**From:** [Connor Armi](#)  
**To:** [Zach Torrance-Smith](#)  
**Cc:** [Guy Moura](#); [Hanson, Sydney \(DAHP\)](#)  
**Subject:** Re: SP-24-00005 Mohar - Notice of Application  
**Date:** Thursday, April 11, 2024 7:28:03 AM

The following are Public Health's comments on the SP-24-00005 Mohar Notice of Application.

**TO:** All Staff  
**FROM:** Public Works Plan Review Team  
**DATE:** April 18, 2024  
**SUBJECT:** SP-24-00005 Mohar

MOHAR FARM SHORT PLAT

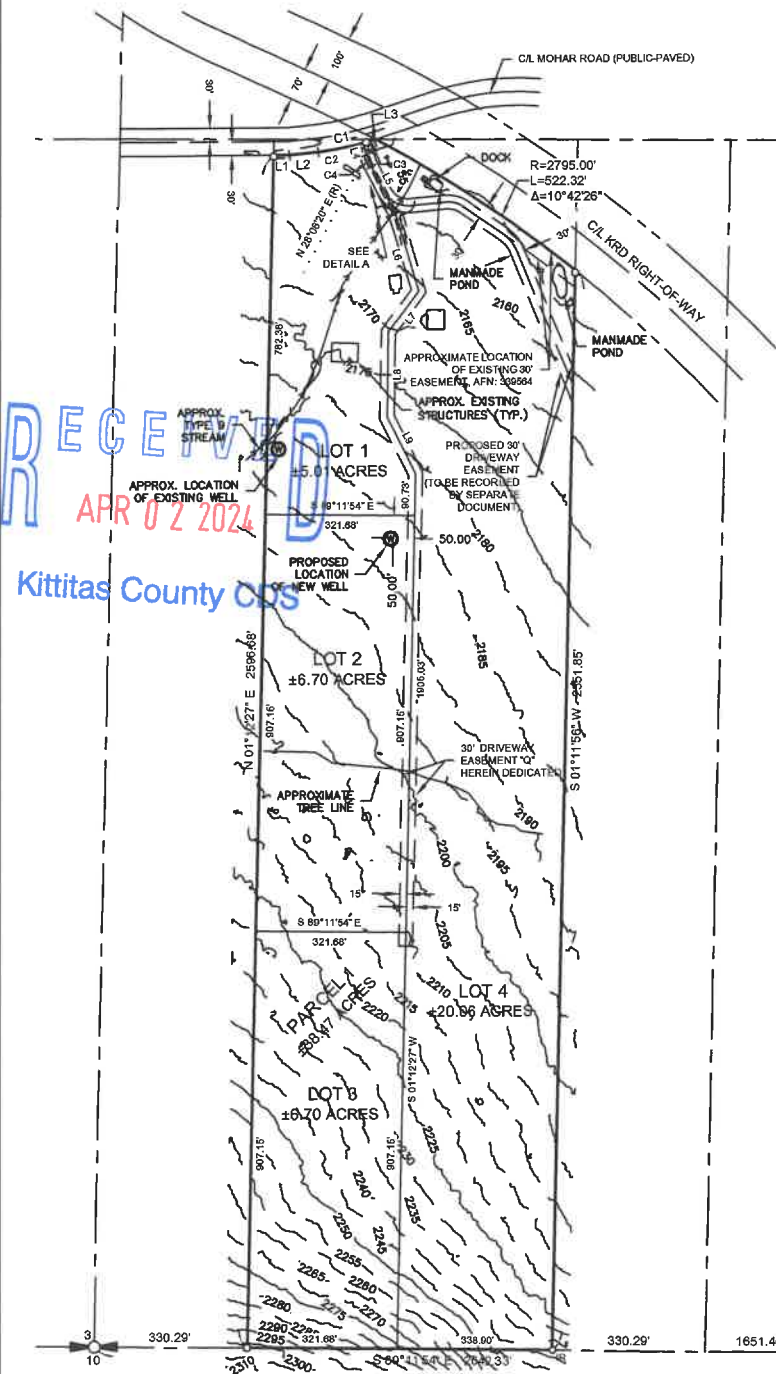
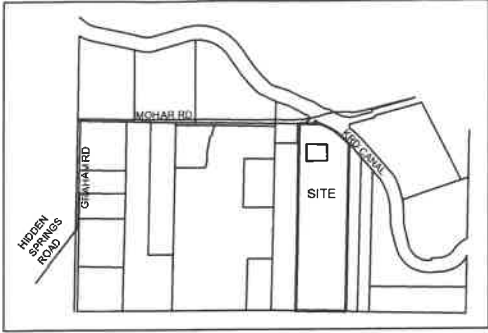
2. Chapter 246-272A-0323 WAC requires configuration of each lot to allow a one hundred-foot radius water supply protection zone to fit within the lot lines; or establishment of a one hundred-foot protection zone around each existing and proposed well site.

3. A signed, notarized and recorded two party shared well users' agreement between each of the lots to be served by the individual wells and well logs for the existing well on lot 1 and proposed well on lot 2 must be submitted to the Health Department for review.

4. If individual wells are to serve each of the proposed lots a well needs to be drilled on lots 3 and 4 and a well log needs to be submitted for each of the proposed lots.

5. KCC 13.04.090 requires at least one soil log to a depth of six feet to be performed at the site of each disposal area on each proposed lot.
